To: Planning **Subject:** 3/2021/0130 **Attachments:** Re_Planning.zip

After consultation with all members of the parish council, we submit the following objection to application 3/2021/0130.

Proposed fence at :	
<b>67 Hillcrest Road Langho BB6 8EN</b>	
CLIENT:	Mr D Houlker
DATE:	December 2020
SCALE:	1:50 @ A1
DWG No:	Fence Elevations
L.A:	
AMENDMENTS:	DATE:
<b>ENTWISTLE DESIGN SERVICES</b>

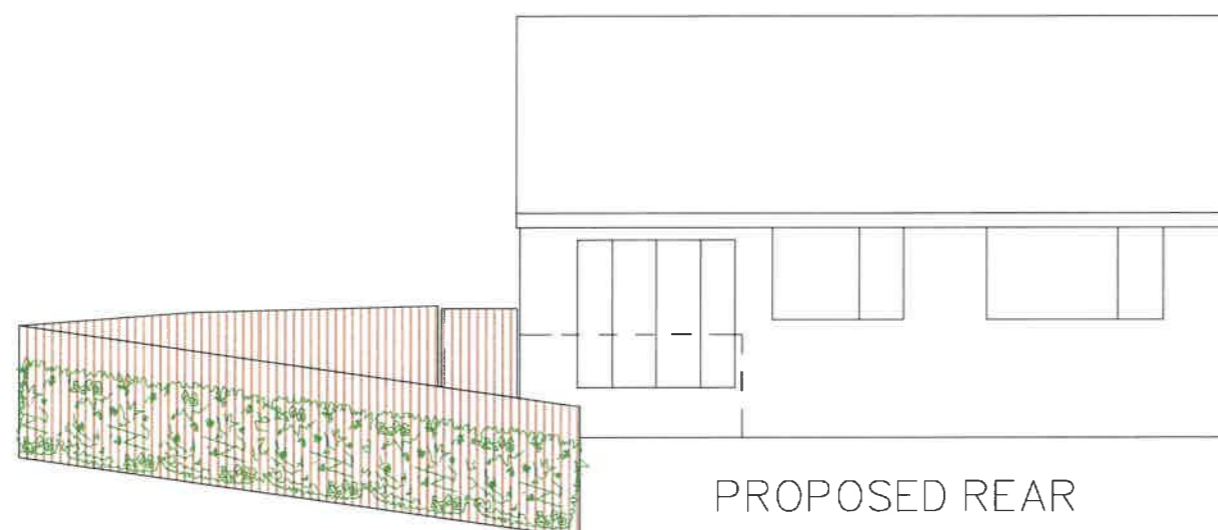
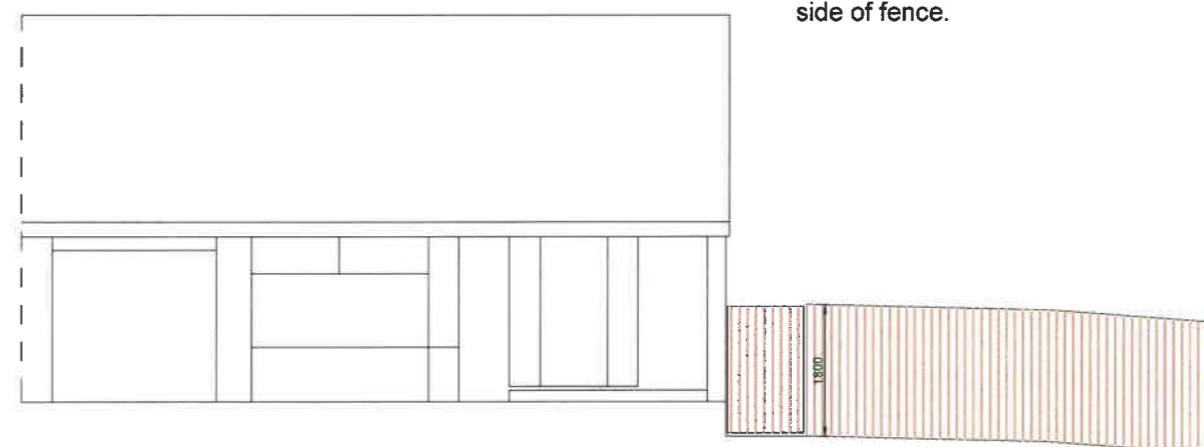
After viewing the fencing at the location, the high fencing is totally out of character with all the surrounding properties. All the estate has no or very low fences resulting in an open aspect to all the houses. Concern was raised as to if there was a covenant restricting the placement / height of the fencing here.

The parish council would like this fencing removed. Attached are photos of the fencing.
